Application no: 22/00638/DISC

Location: Begbroke Science Park, Begbroke Hill, Begbroke, Oxfordshire, OX5 1PF

Transport Development Control

Oxfordshire County Council **Object** to the discharge of Condition 18 'Turning area specification'

TITLE: **Additional 7 parking Spaces**

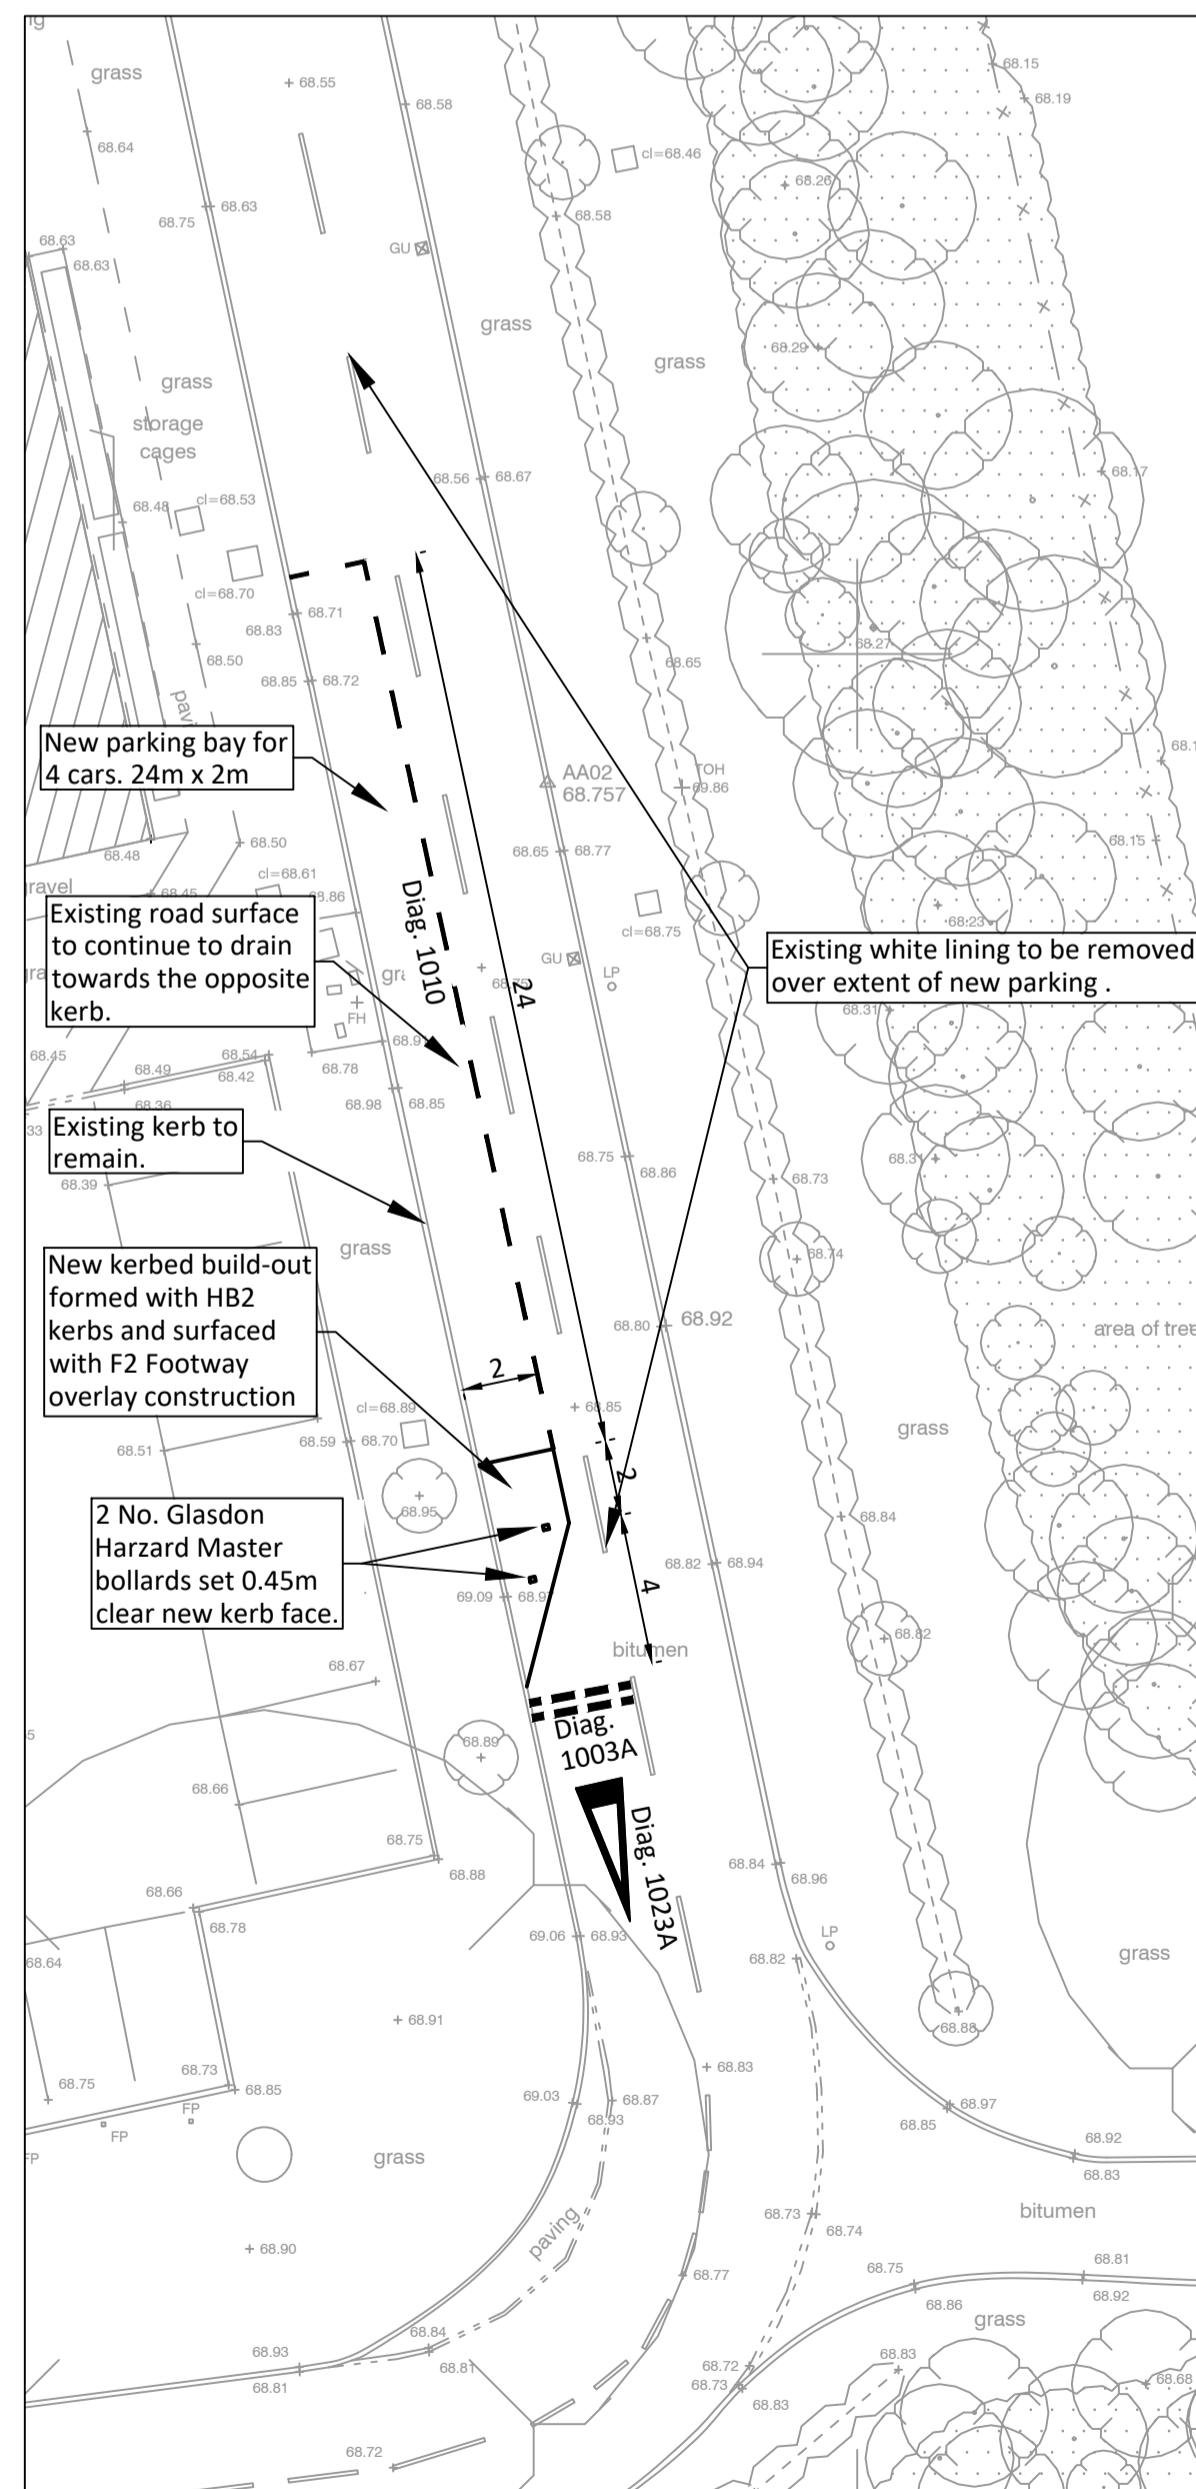
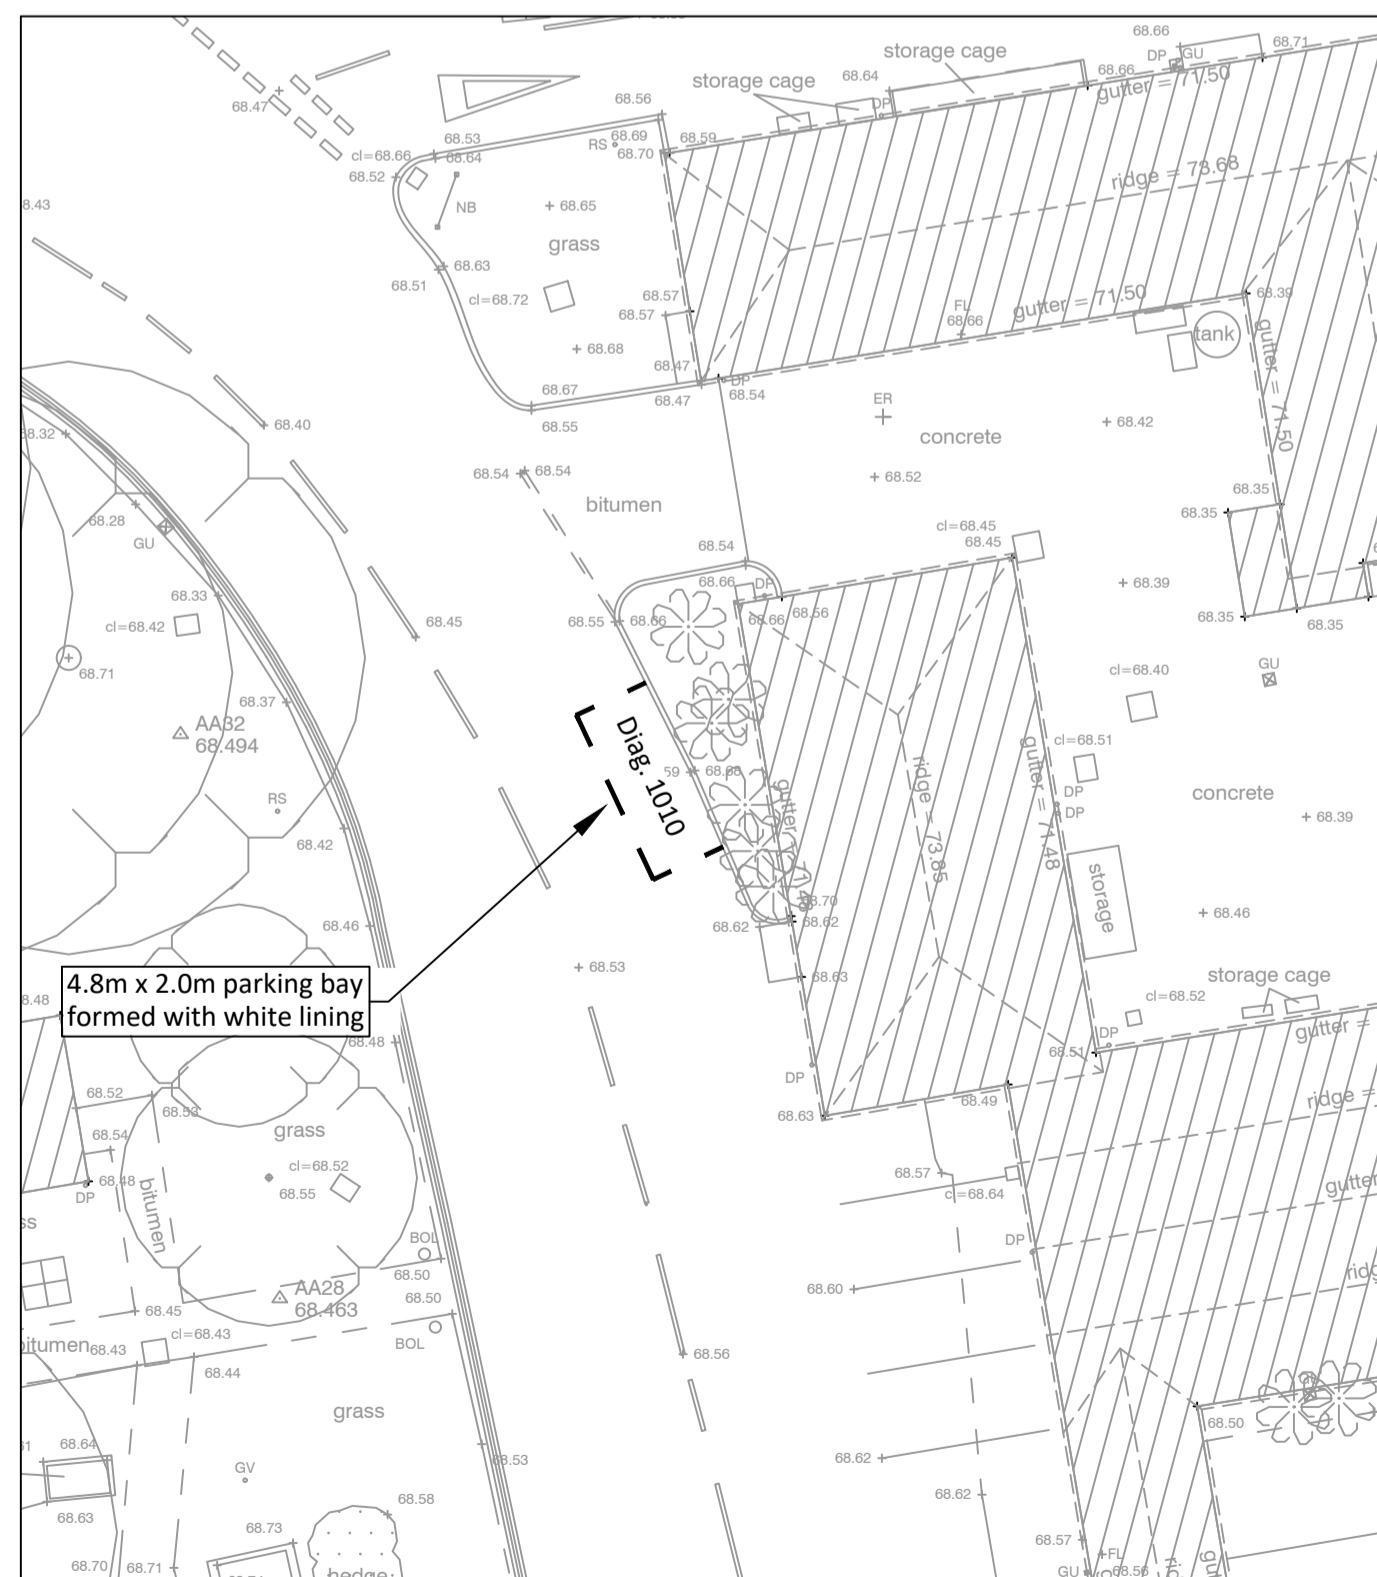
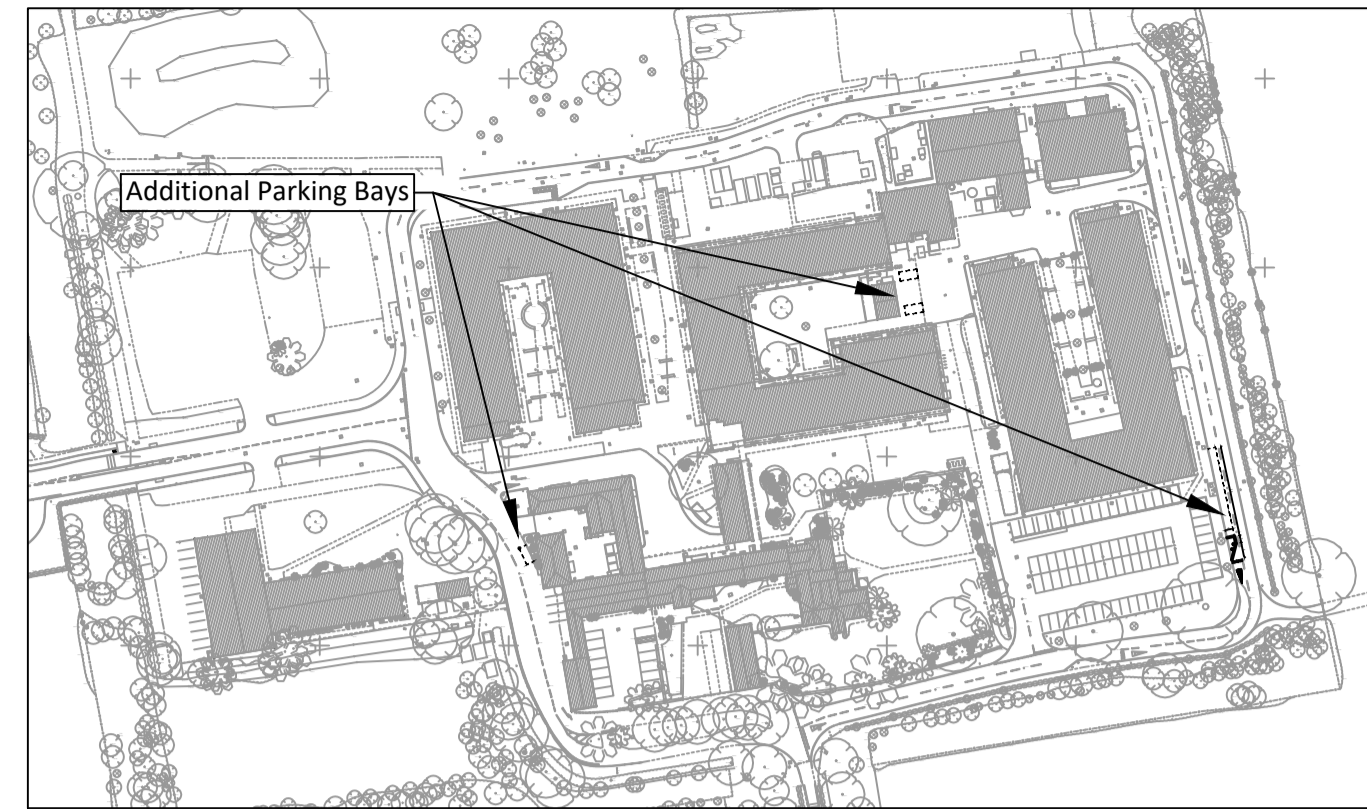
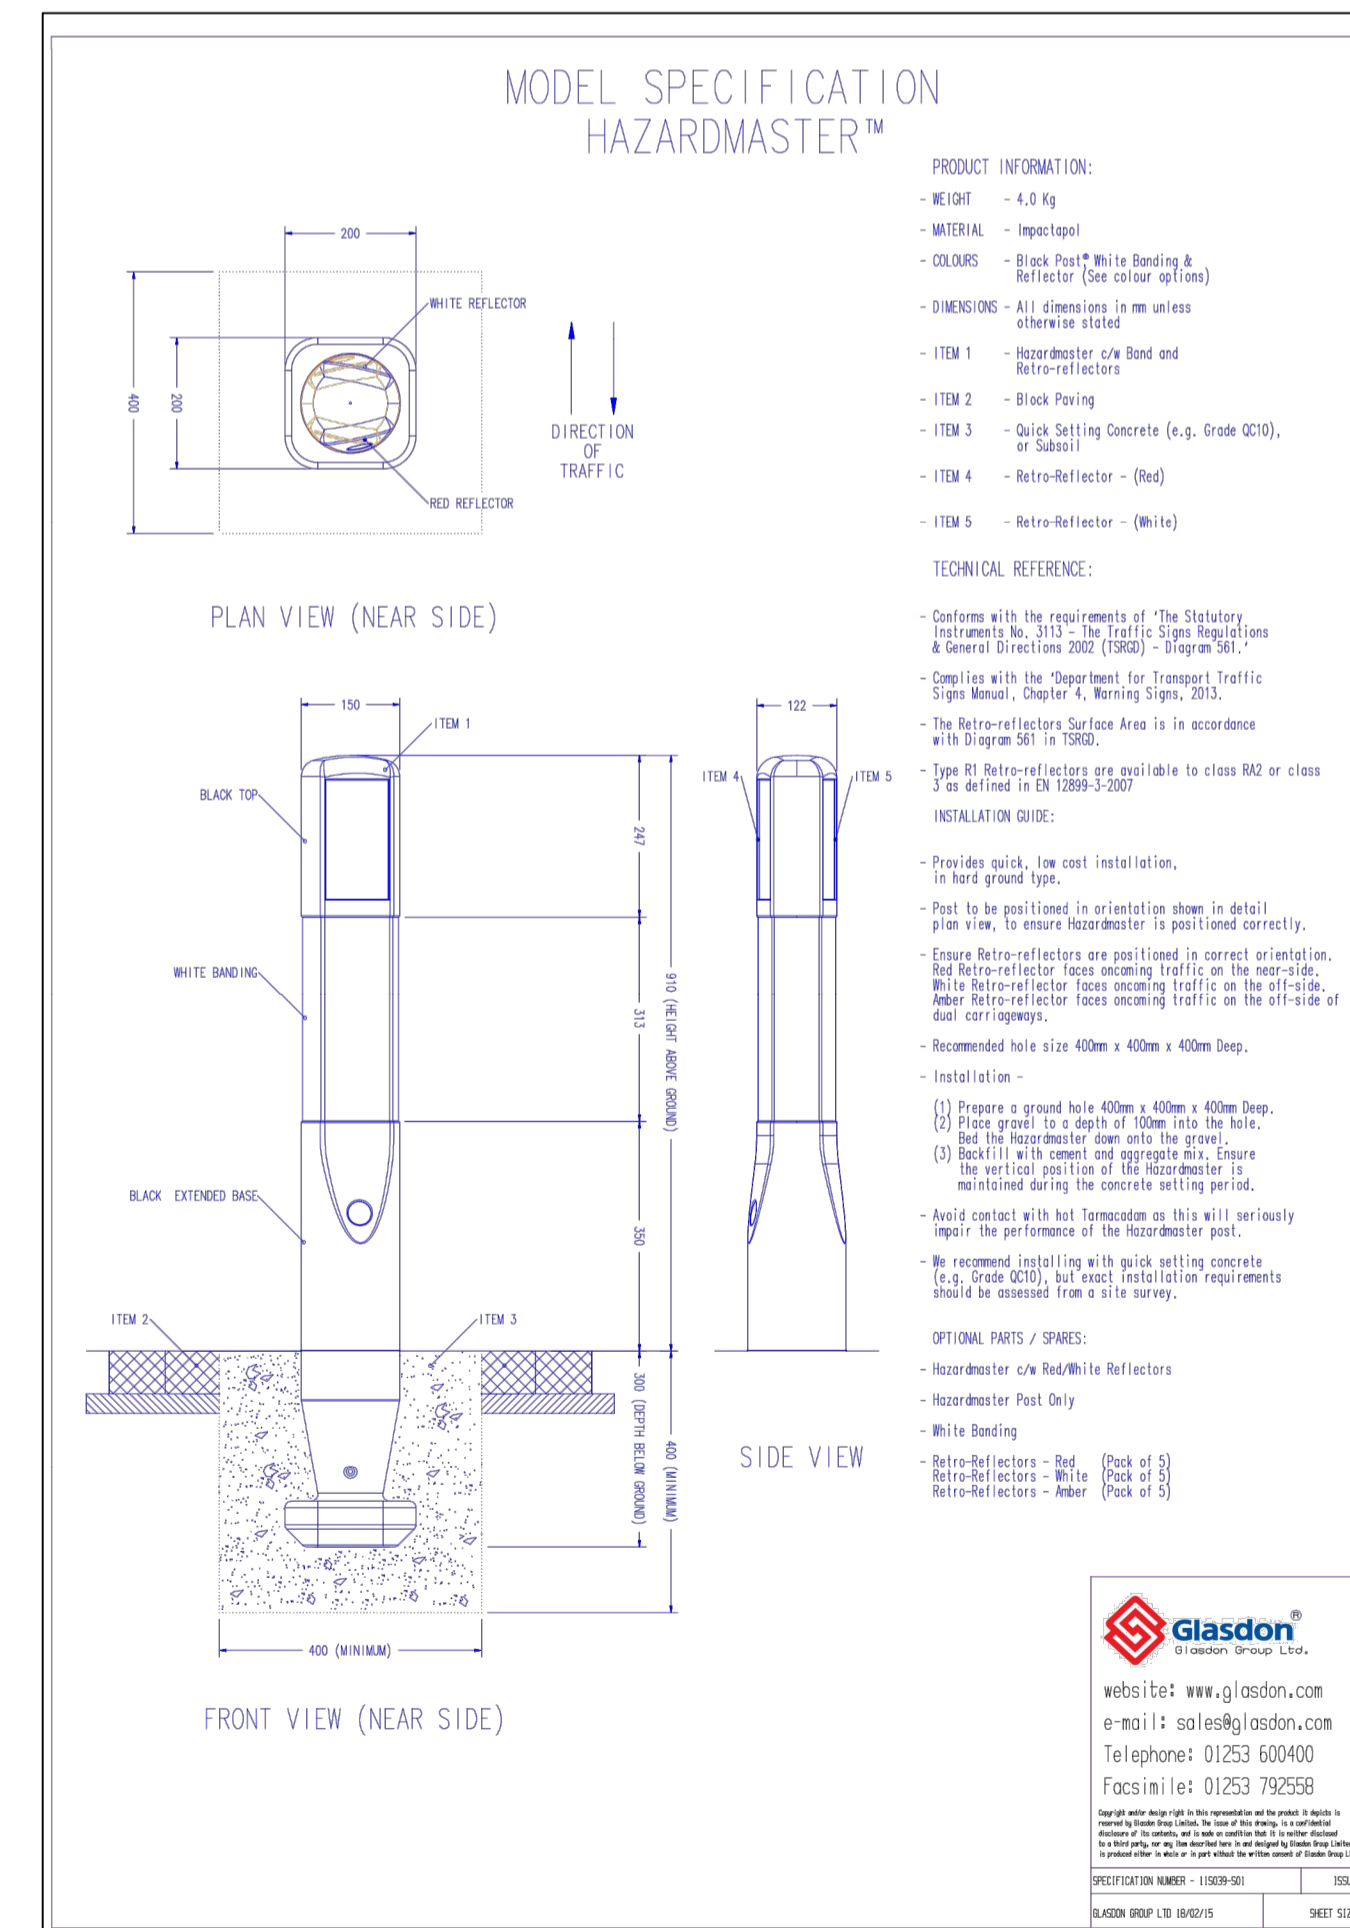
The OCC guidance for space between vehicle parking bays measures at 6.0m so that cars can 'swing' into spaces. Many of the spaces within the following car parks including the 'New Surfaced Car Park, OGT/IAT, Units 5 & 6 do not have this space. This ultimately jeopardises the condition as it may restrict vehicles' ability to reverse and leave the car park forwards as well as general manoeuvrability and convenience. This is emphasised by the exclusion of a turning area, this will need to be amended before the condition can be discharged.

The Parking proposal states that the amount of vehicle parking spaces when including disabled spaces should total to 414. When including the unallocated, parallel parking bays, it totals to 418. It must be confirmed, before discharging this condition, the exact number of spaces that are within this development.
